PUBLIC TESTIMONY
MERCER ISLAND PLANNING COMMISSION
01/30/19

City of Mercer Island Planning Commission, Staff, and Council:

1. The "tiered" system: Small Sites vs Large Sites.

PRELIMINARY STUDY
HERZL - LOT COVERAGE

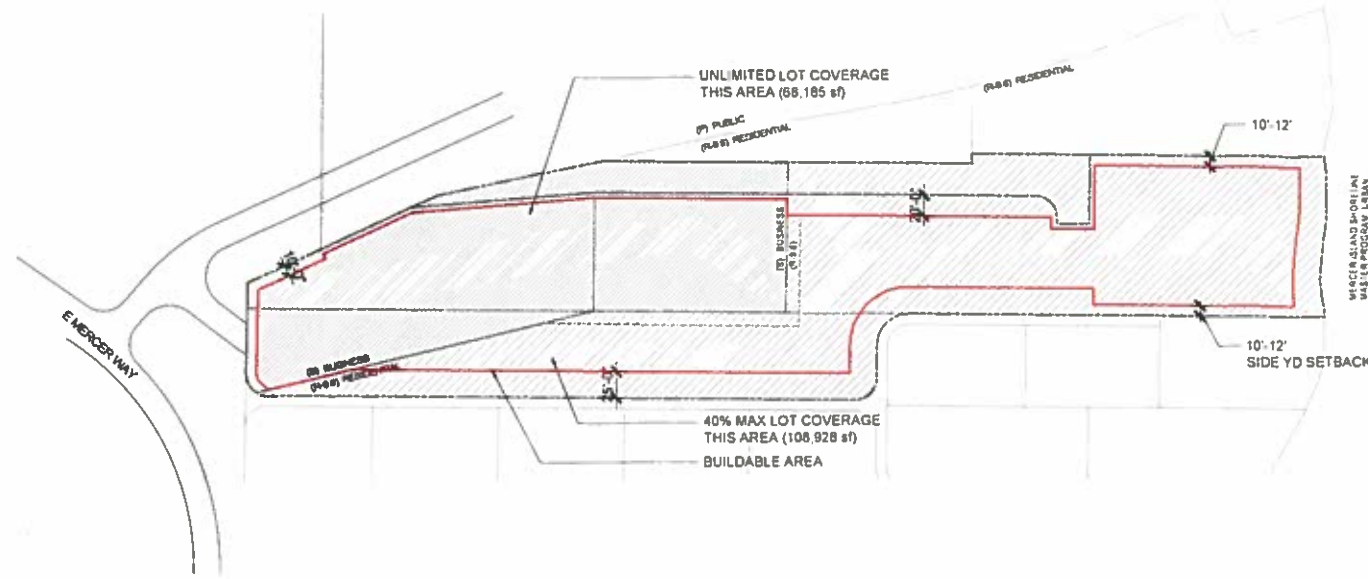
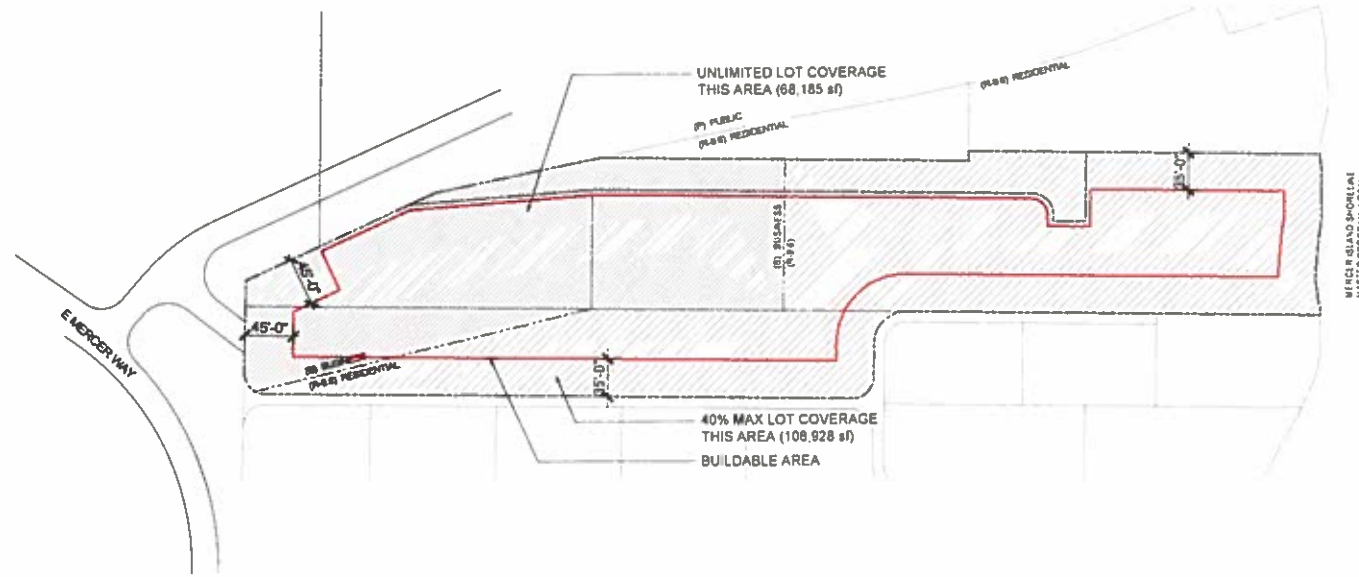
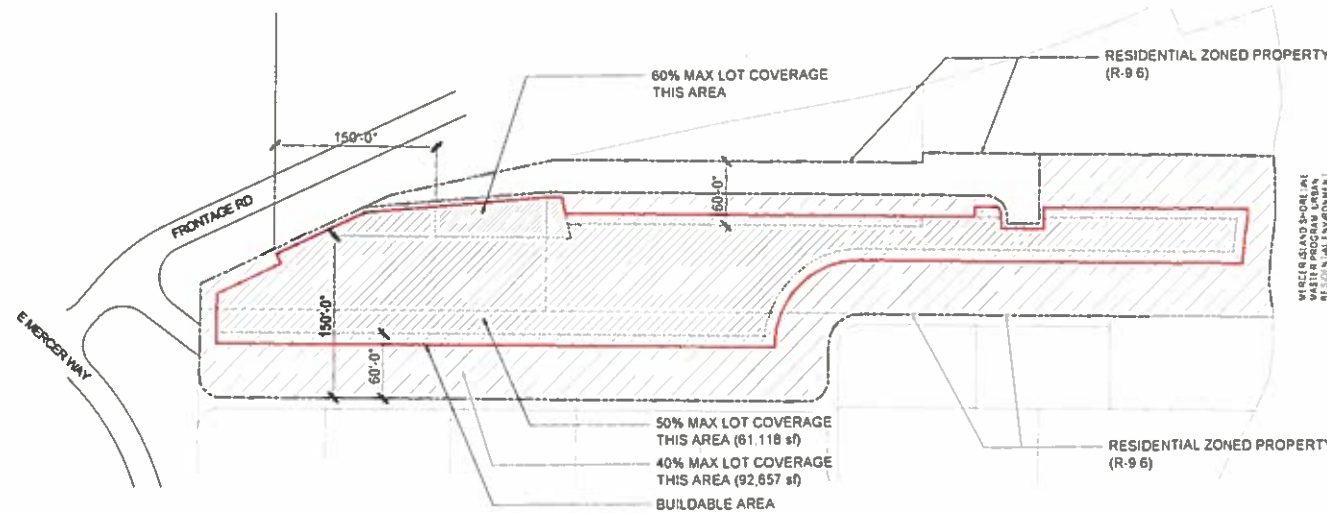
- As the first diagram in your set illustrates, the effective Lot Coverage has been reduced by one third (1/3), from approximately 63% under the existing mix of Business (B) and Residential (R-9.6) zoning to less than 40% under the CF zone. For reference, the existing Herzl site has a coverage of approximately 58%, and the existing leased school site, which is fully utilized, has a coverage of approximately 50%.¹

We appreciate that coverage is intended to address development intensity as well as environmental performance. For small infill sites, we recommend establishing a more realistic site-wide target of 55-60%, or to base coverage on site-specific conditions and geometries, recognizing that the stormwater code will ensure environmental performance.

PRELIMINARY STUDY
HERZL - GROSS FLOOR AREA

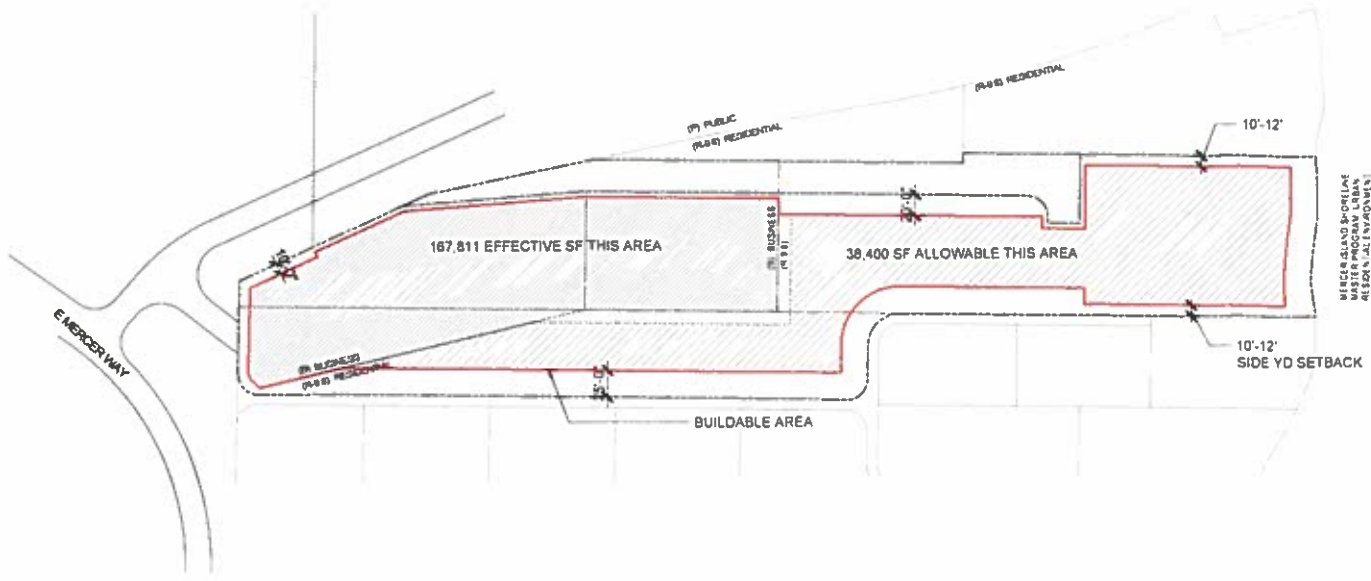
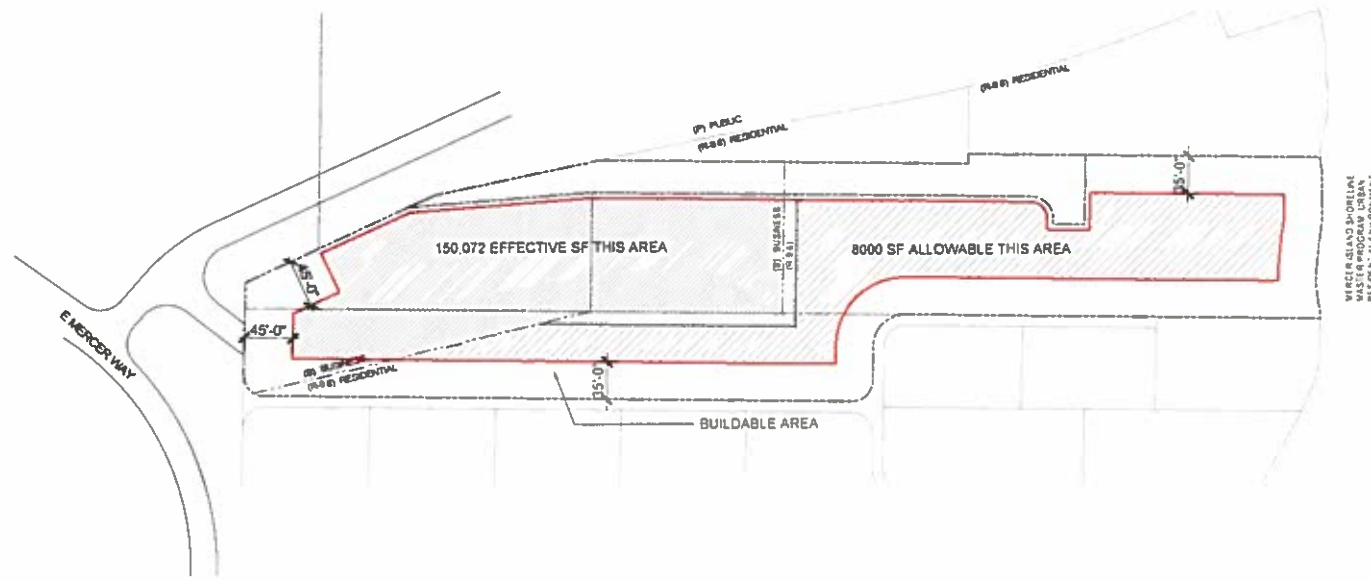
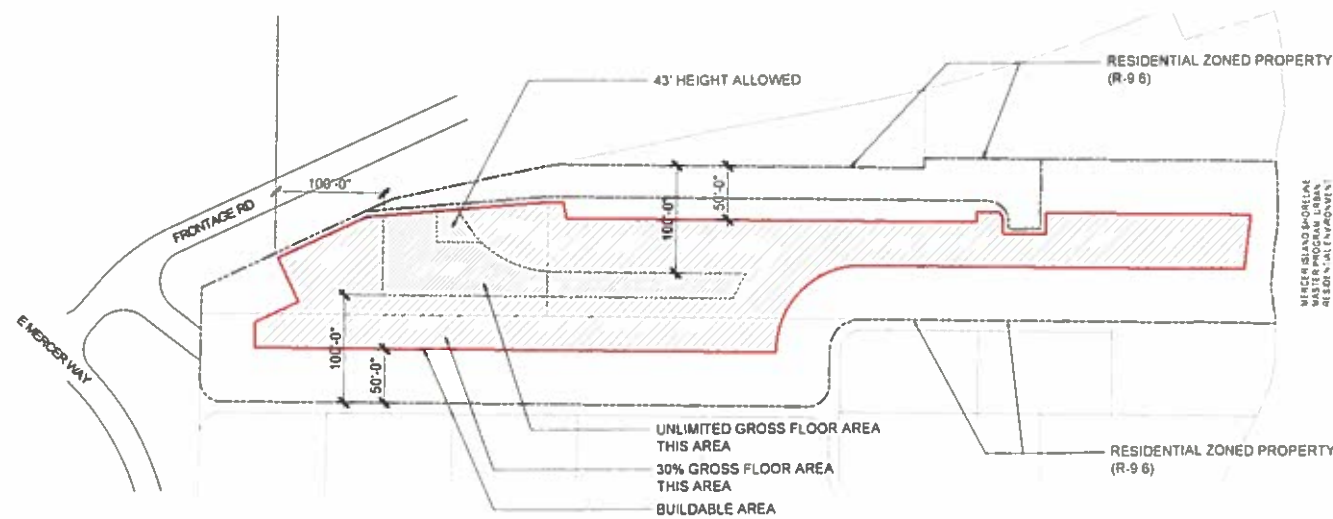
- As the second diagram in your set illustrates, the effective Gross Floor Area on Herzl has been reduced by 75% from the existing mix of Business (B) and Residential (R-9.6) zoning. We are embarking on this master planning effort so that we may have the ability to evolve our curriculum and modernize our facilities. If we were to build new program based on the 2017 State Office of Public Instruction median building area per student (135sf/student), the new CF zone GFA limits would require us to reduce our enrollment by 90 students, or 20%.²

We suggest considering alternatives to setback-based floor area standards, such as site-wide FAR, or instead, relaxing the setbacks.

**PRELIMINARY STUDY
HERZL - SETBACKS & BUFFER
1"=40'**

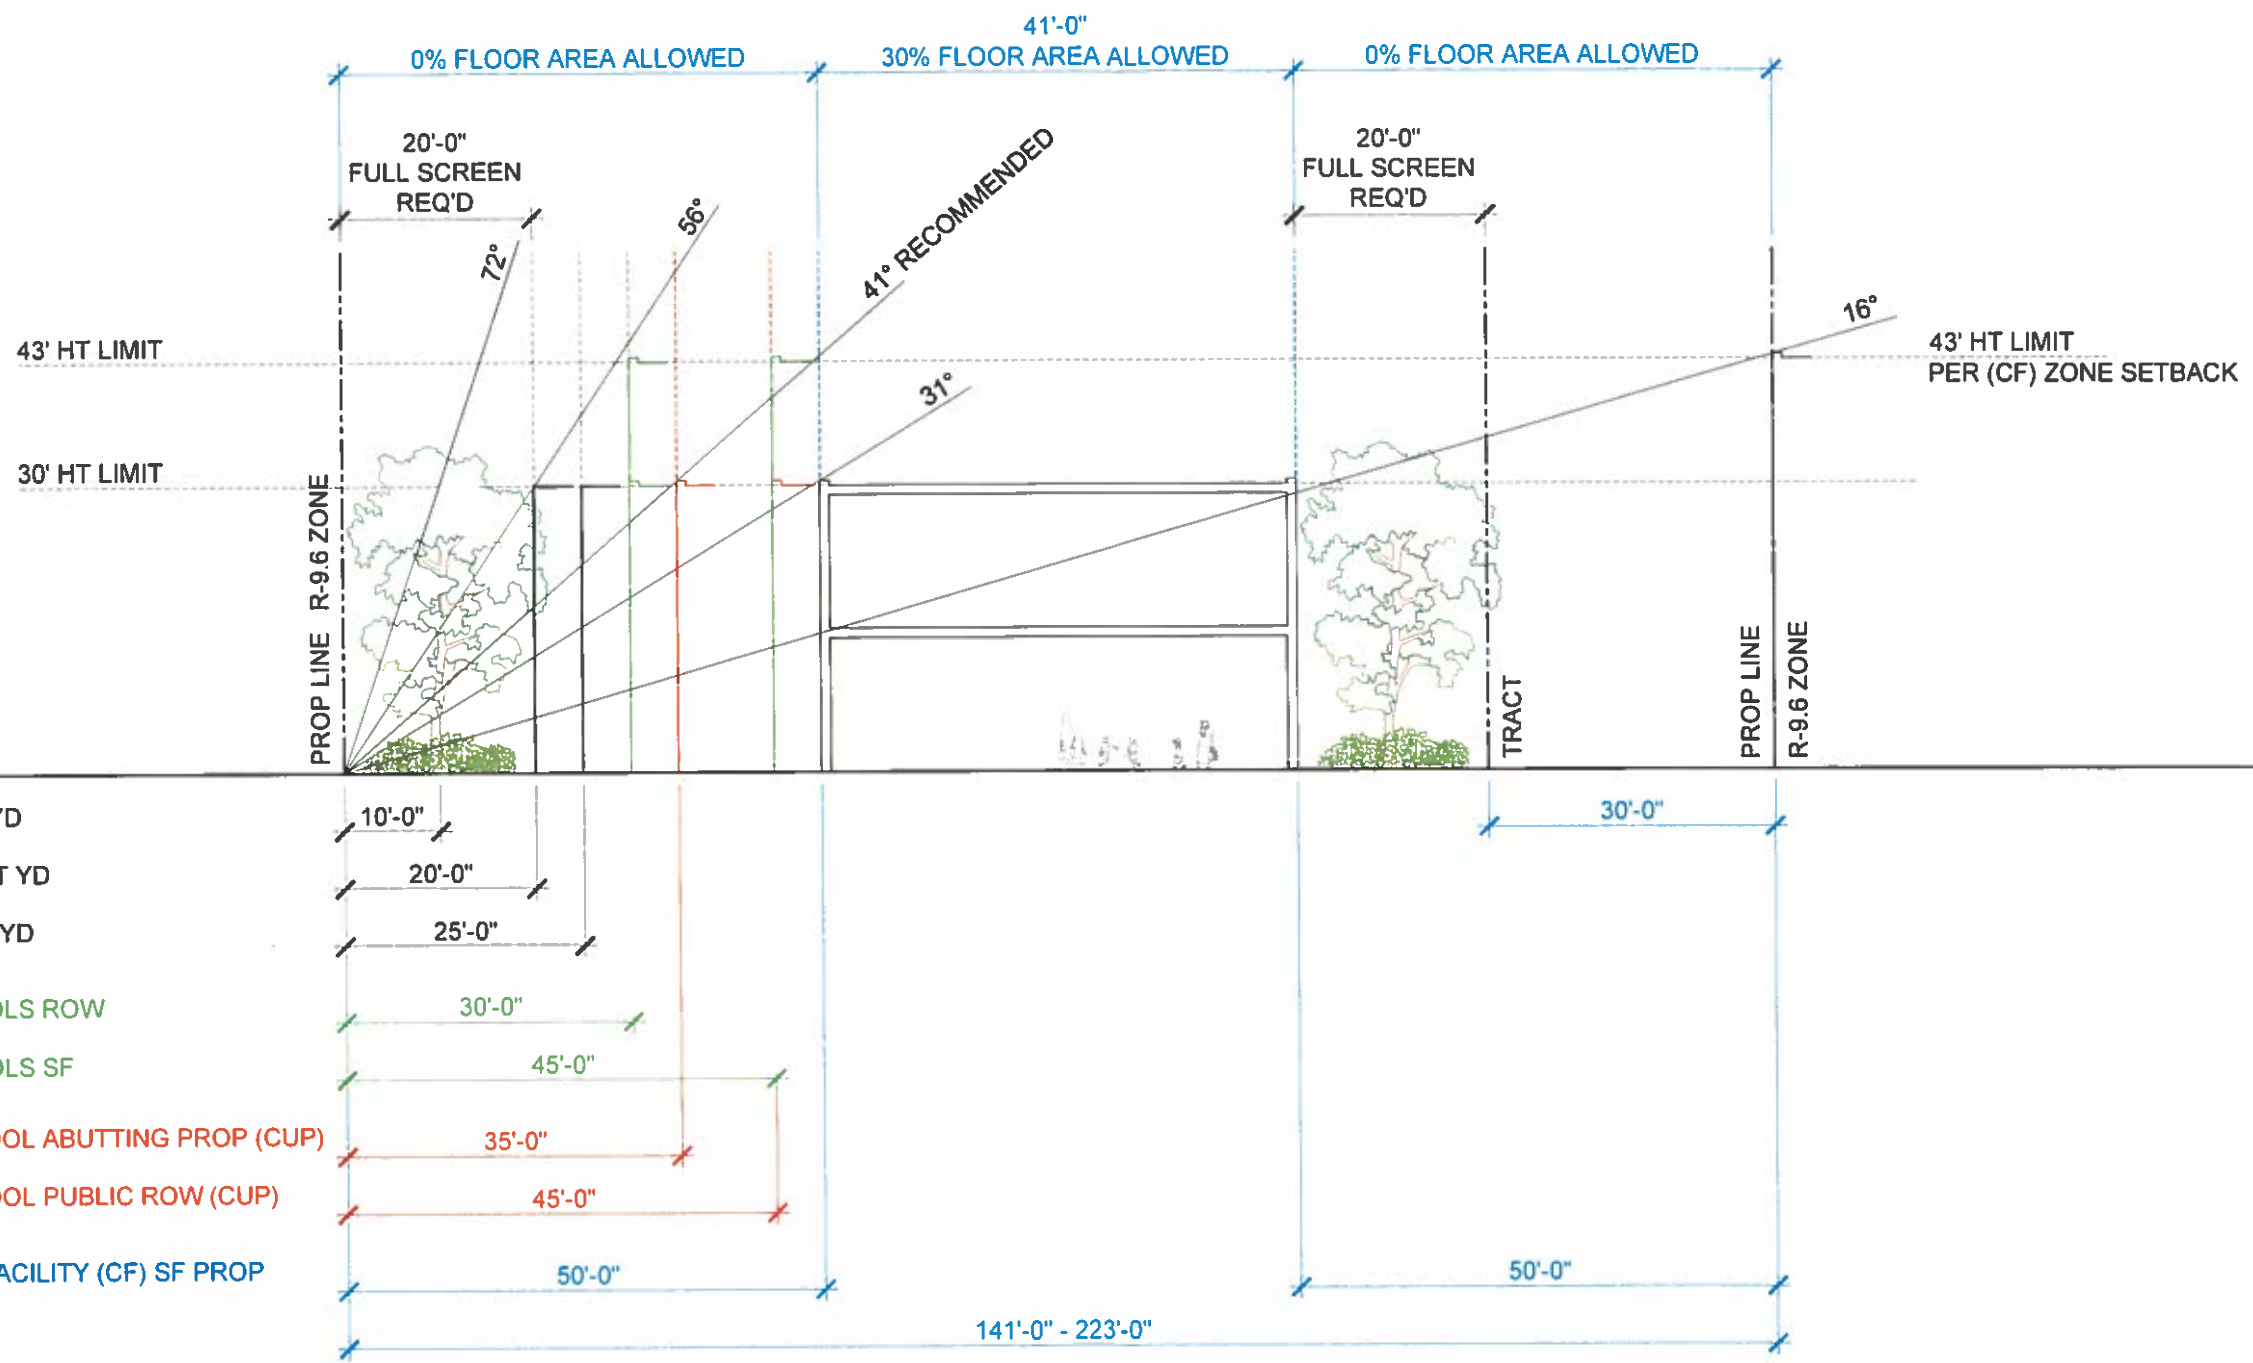
- As the third diagram in your set illustrates, the developable area on Herzl (excluding the access tract) ranges between 111’ to 193’ in width. The proposed 50’ setbacks on either side leaves an unreasonably narrow area for new school development – and relative to building height, the code sets an “impact angle” that is also unnecessarily restrictive. For reference, existing R-9.6 zoning allows an 8,000 gsf, 30’ tall single-family structure to occur within 10’ of a side lot line without screening, an impact angle of 72%.

We suggest that reasonable accommodations be made to establish usable areas for building heights, and setbacks should be written to be site-specific, similar to the existing Public Schools development standards.

PRELIMINARY STUDY
HERZL - BUILDING HEIGHT

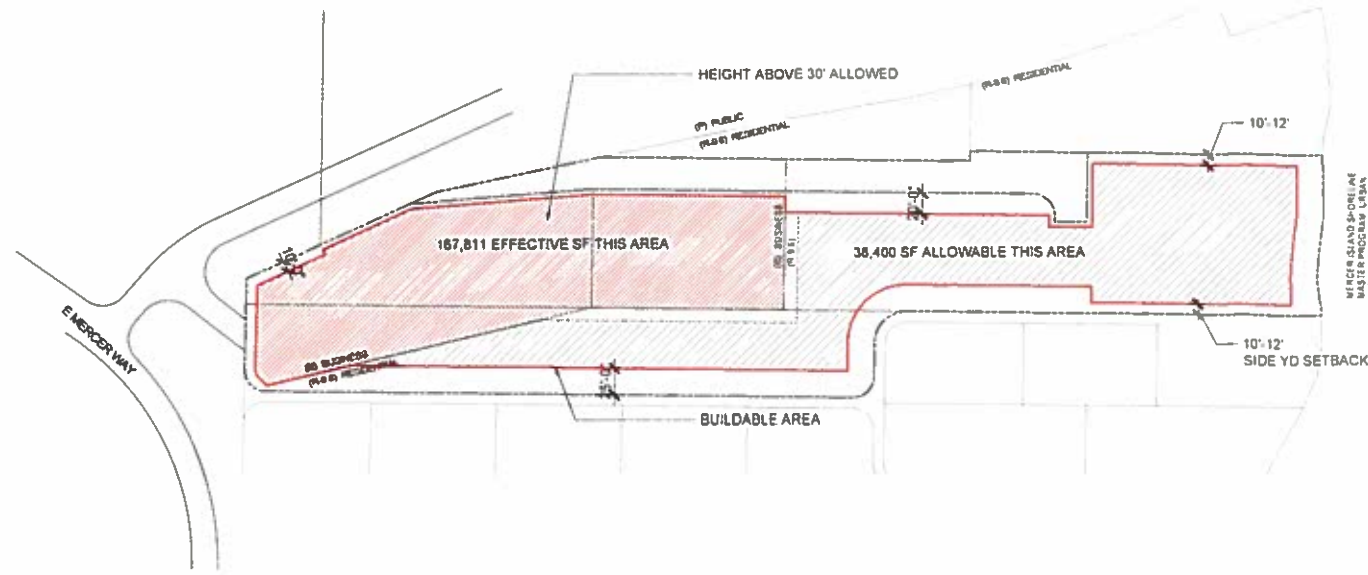
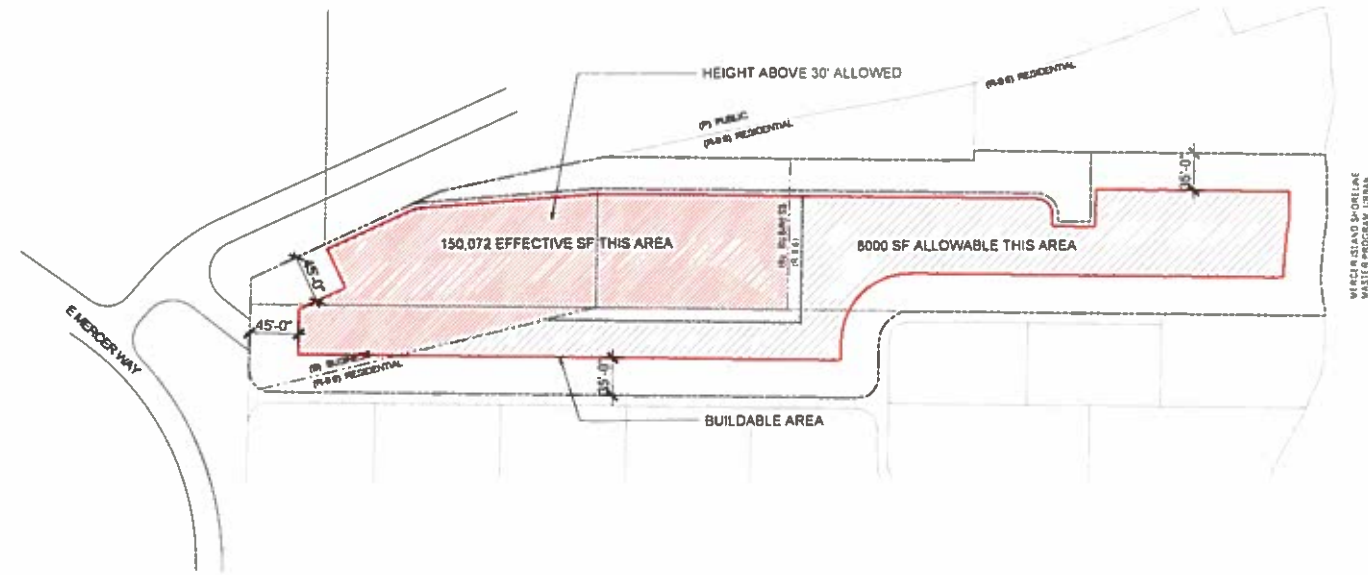
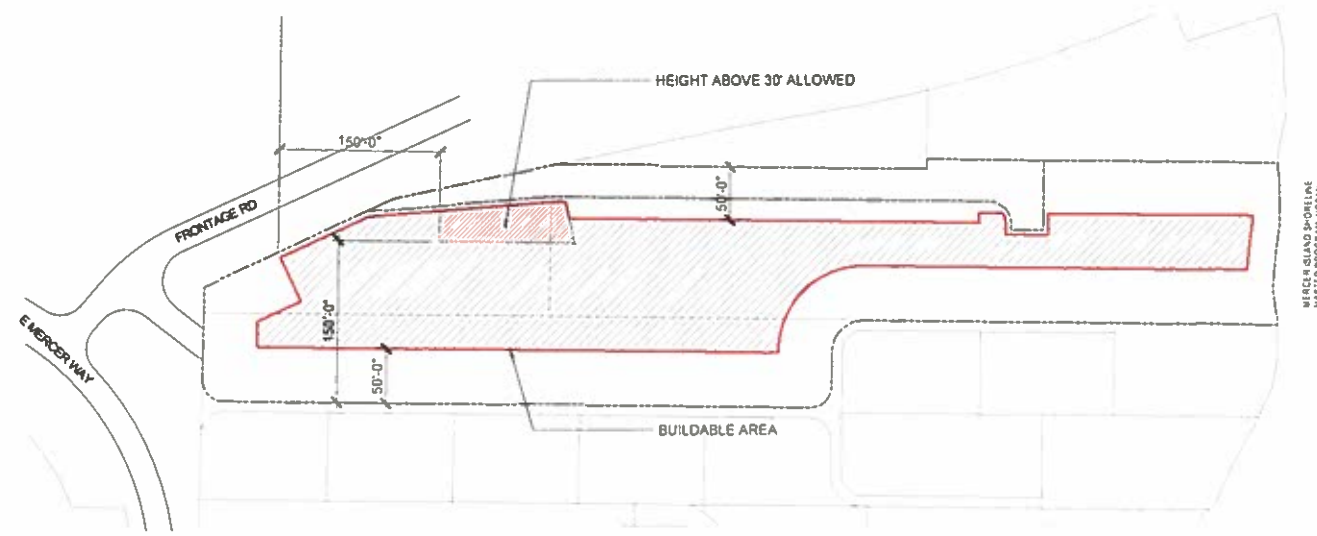
We agree with the need to address the visual impact of building bulk. Together with full screening within 20' of any residential lot line, we believe the existing "impact angle" for private schools permitted as a conditional use in R-8.4 and R-9.6 zones, or 41 degrees, is sufficient as the baseline for the new CF zone. Additional stories should be permitted under this "impact angle," subject to design review and other controls within the code. Looking at the next diagram in your packet, one can see that the lot area available for three stories, based on setbacks alone, is unusable.
